Our reference: SDP25/0011
Contact: Sandra Fagan
Telephone: 4732 7992

Council Response to Request for Advice on SEARs - SSD-92743706 - Mamre Road Data Centre at 706-752 Mamre Road, Kemps Creek

Figure 4. Proposed development plan - Data Centre Campus

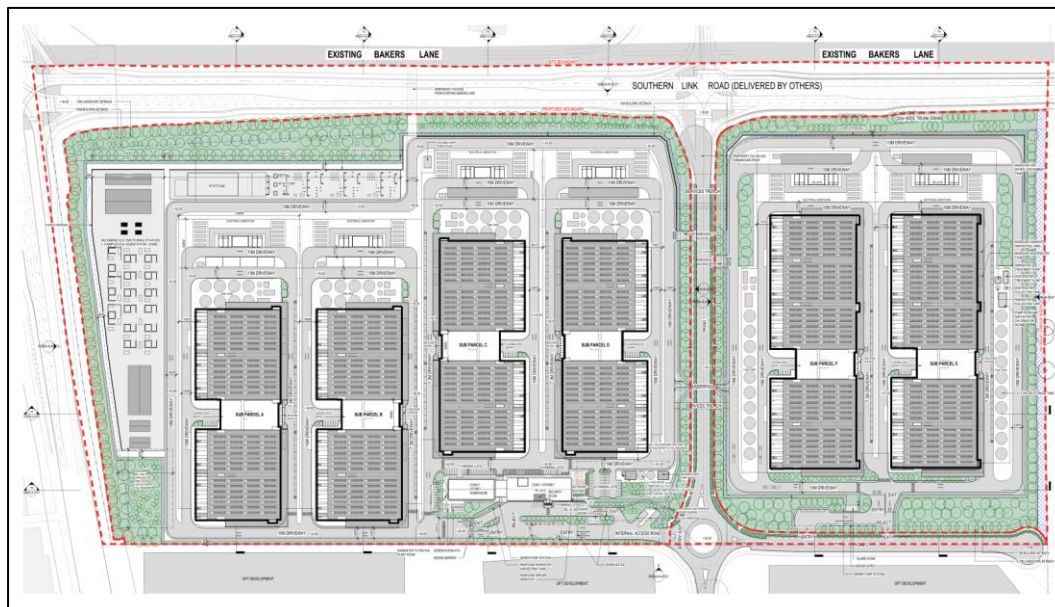
- d) A Visual Impact Assessment given the multiple structures proposed. This should include photomontages at various vantage points. The proposed layout and density of the development does not provide adequate visual relief into, around and within the site. The Department should require the Proponent to engage with the State Design Review Panel.

- e) A design principles analysis addressing the justification for the apparent uniform nature of the architectural expression and language of the structures. The use of what appears to be ‘false windows’ on elevations of all the buildings potentially gives the overall appearance of a residential block structure. The building language is confusing and homogenous. The uniform approach exacerbates the visual clutter and overbearing nature of the building mass and does not allow each group of buildings to have its own identifying elements or be visually broken up. The Objectives (‘Design Principles’) of Section 2.30 of the State Environmental Planning Policy (Industry and Employment) 2021, should inform the analysis and justification.

It is noted that in some areas the proposed height is 50m from natural ground, representing a 250% non-compliance with the 20m height requirement. This should be addressed having regard to the objectives and controls of Part 4.2.1 of the Mamre Road Precinct Development Control Plan 2021.

- m) Explanation of roads and / or infrastructure intended to be dedicated to Council, including timing of proposed completion of (future) public roads. For example, the small cul-de-sac road along the southern property boundary, which is accessed from the western side of the round-about appears to be a 'private road', and the function and division of 'private' versus 'public' may be confusing.

Figure 7. Proposed Landscaping – Data Centre Campus

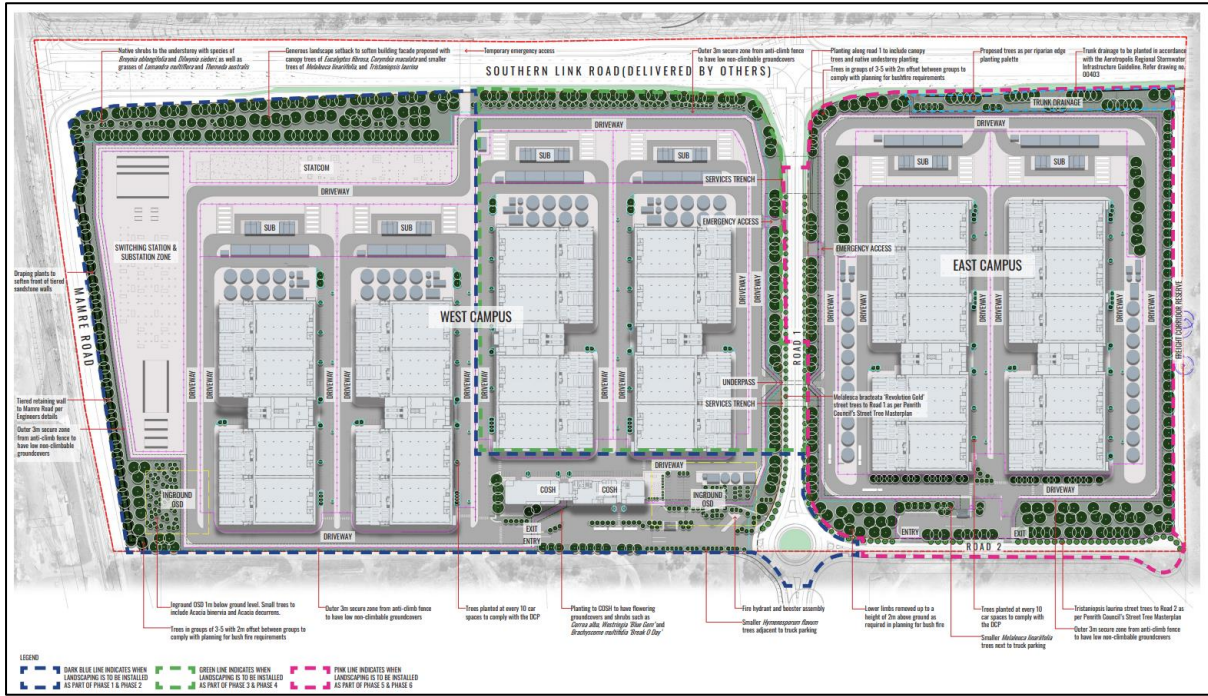
Structures in landscaped setbacks, including underground structures, are not supported. The Mamre Road setback should be planted informally with a mix of tree species from Council's Draft Street Tree Masterplan, delivering consistency along the corridor, biodiversity and maximum canopy coverage. Understorey plantings shall be sufficient to provide full height and dense screening to built forms on the development site, including large and medium native shrubs as required.

- j) Given the significant non-compliance with height, it appears that the proposed tree planting and canopy coverage will not provide the required visual screening of the structures. The use of retaining walls in landscaped setbacks (particularly along the Mamre Road frontage) diminishes the ability to provide desired landscaping. The proposed building forms continue to rise above the top of the
